Recommendation Report for Planning Permission for Works or Extension to a Dwelling

REF NO: LU/257/20/HH

LOCATION: 2 Meadow Way
Littlehampton
BN17 6BW

PROPOSAL: Two storey brick side extension under tiled roof

STATUS	APPLICATION	DATE	1/10/2020	3353/04	1/10/2020
CLIENT	MR & MRS BURCHILL	DATE	21/08/20		
PROJECT	2 MEADOW WAY LITTLEHAMPTON BN17 8BW				
DESIGNER	PROPOSED FLOOR PLANS AND ELEVATIONS

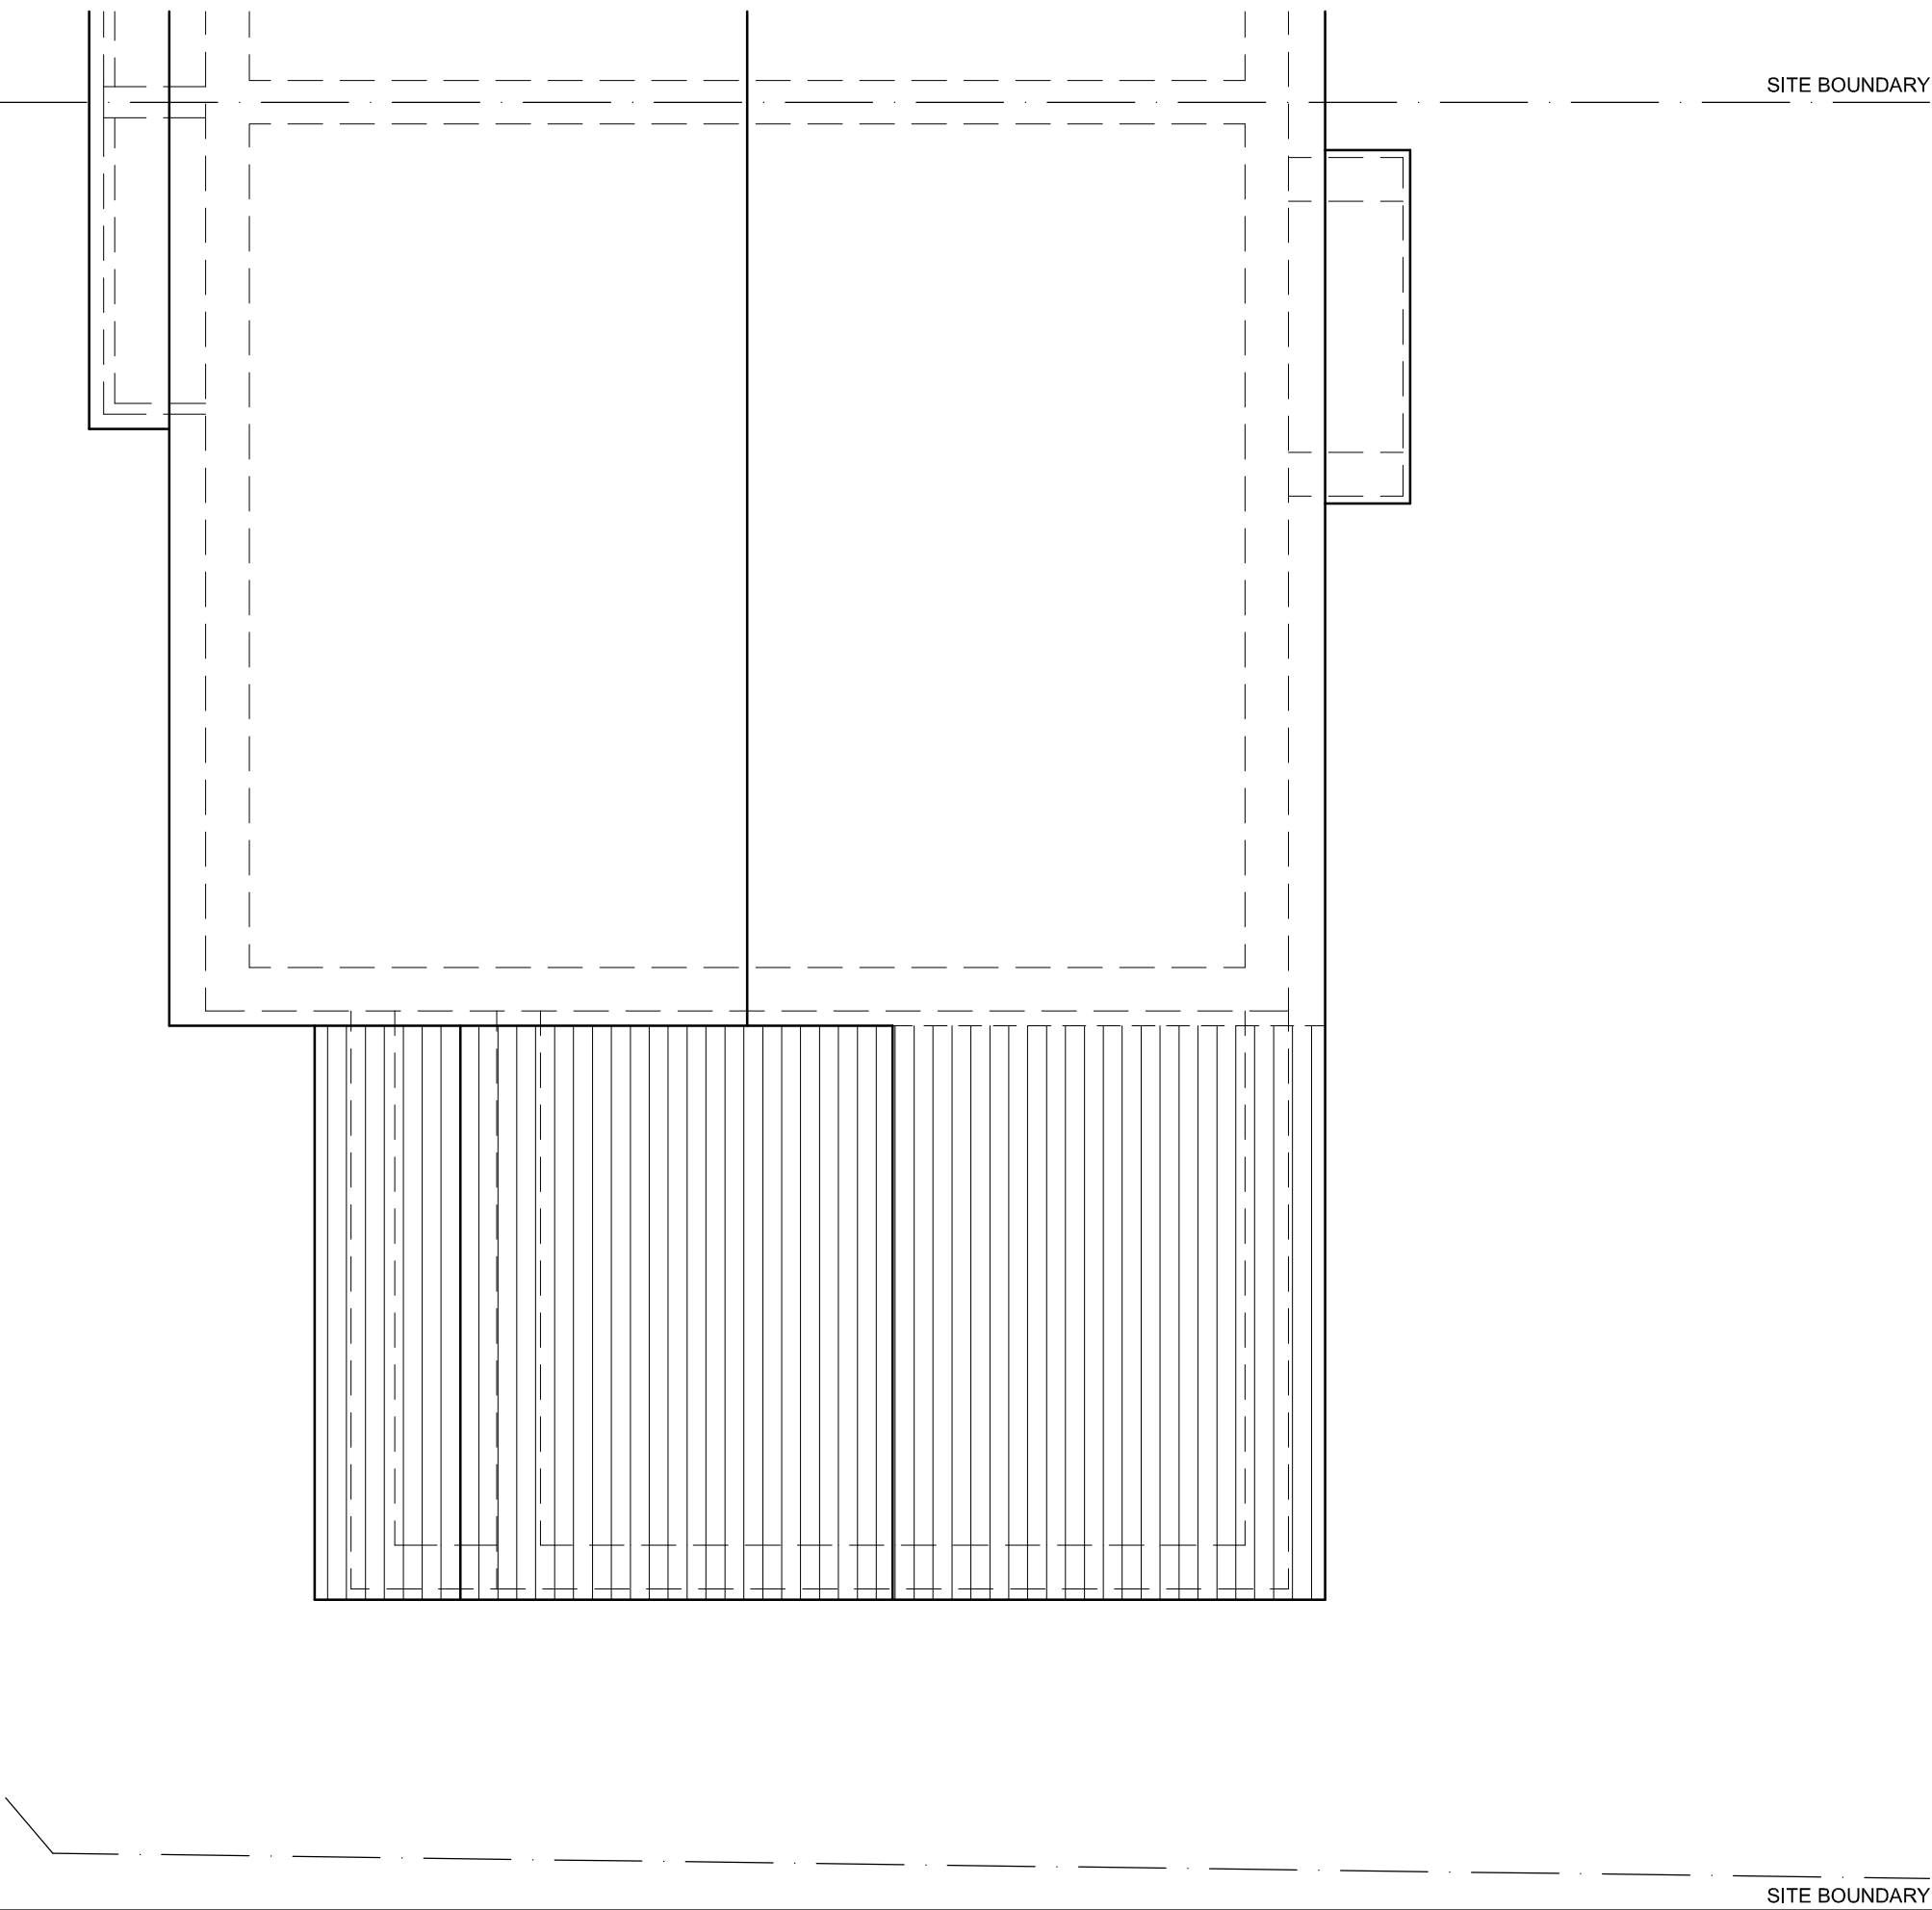
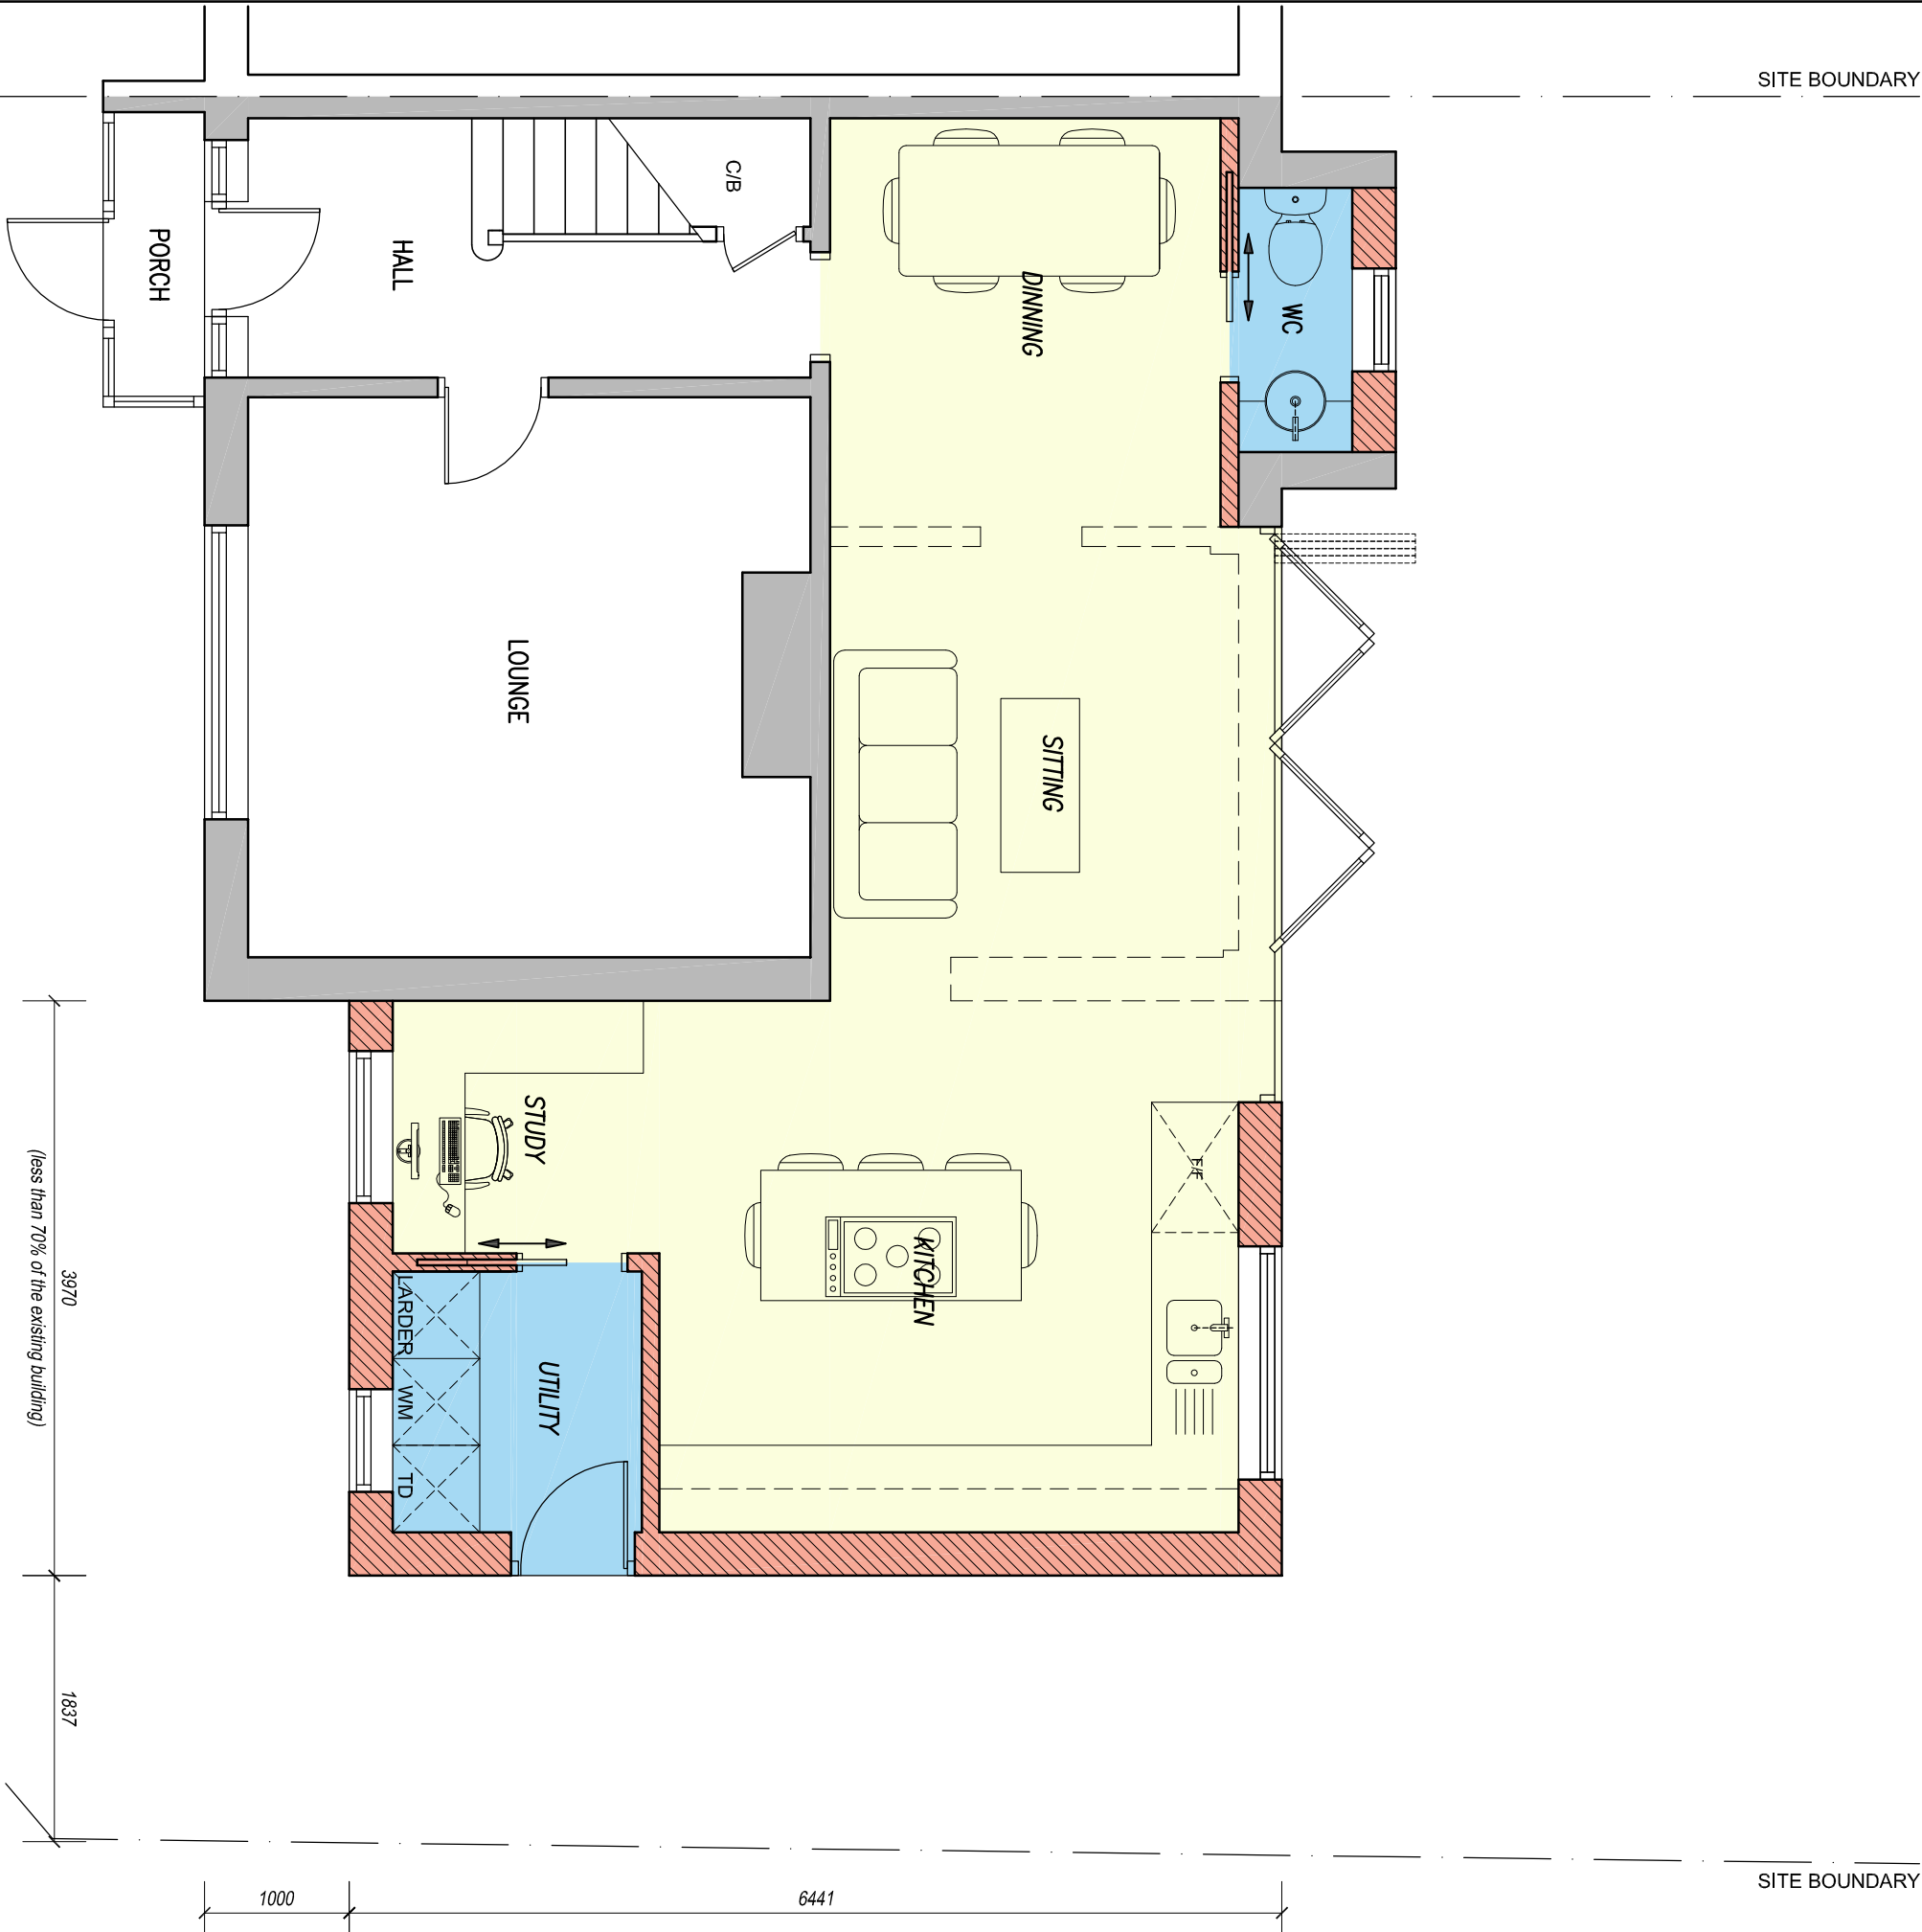
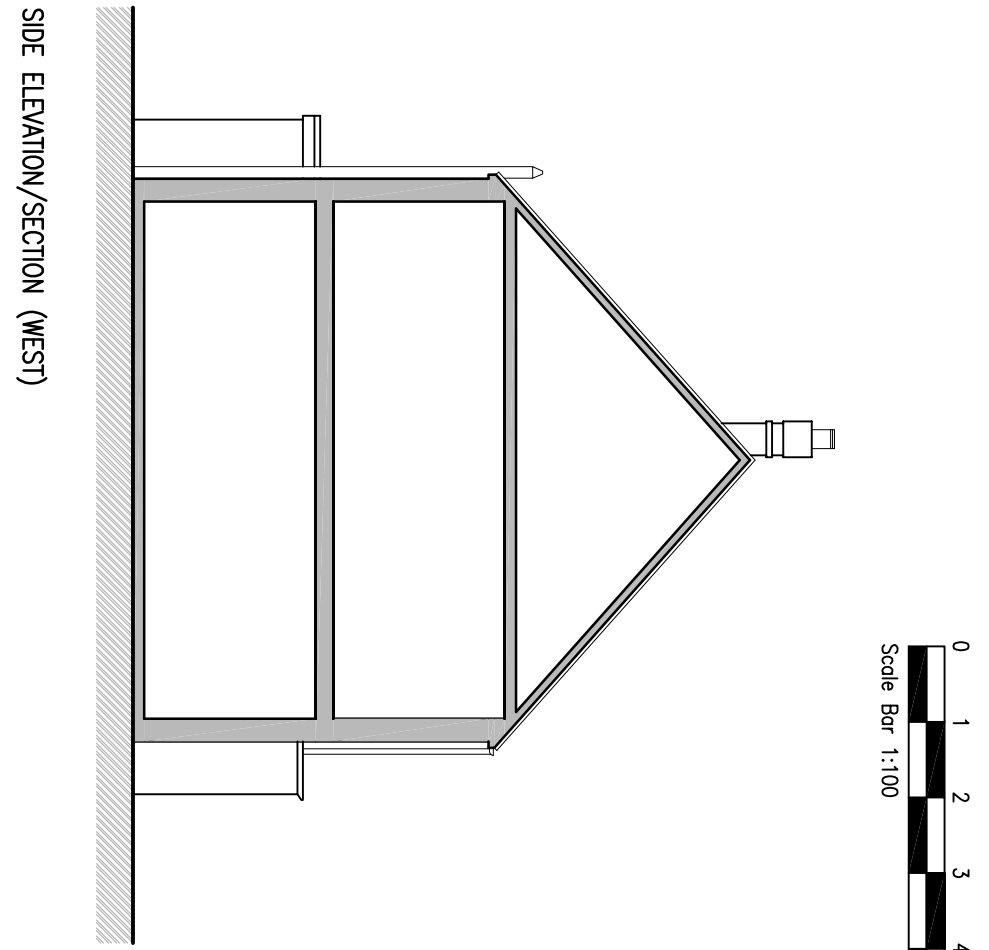
Due to its siting, the development would be highly visible in the street scene of Meadow Way and Esher Drive. As such, there are views of the extension from the immediate and wider locality given the existing prominence of the property within the street scene. The existing Eastern wall of the host dwelling is approximately 6m from the boundary, in conformity with the character and appearance of the area, being characterised appearing reasonably spacious and open, due to the built form being set back from the street scene in a constant and uniform manner. Whilst the set back nature of the proposal from the street scene, and the ridge height are noted as allowing the extension to appear subservient to the host dwelling, it is considered to appear as an alien feature within the wider locality, and have a harmful impact upon the uniform character of the Northern side of Meadow Way.

The development is considered to appear as an alien feature within the locality, and as such, will result in a significantly harmful impact upon the character of the locality, and its established spatial pattern. The proposed development is considered to be in accordance with D DM4(b) of the Arun Local Plan however, it conflicts with D DM1 and D DM4(e) of the Arun Local Plan.

- 1 The proposed development is considered to result in a harmful impact upon the character and spatial pattern of the locality by way of its siting, form and design contrary to D DM1 and D DM4(e) of the Arun Local Plan.
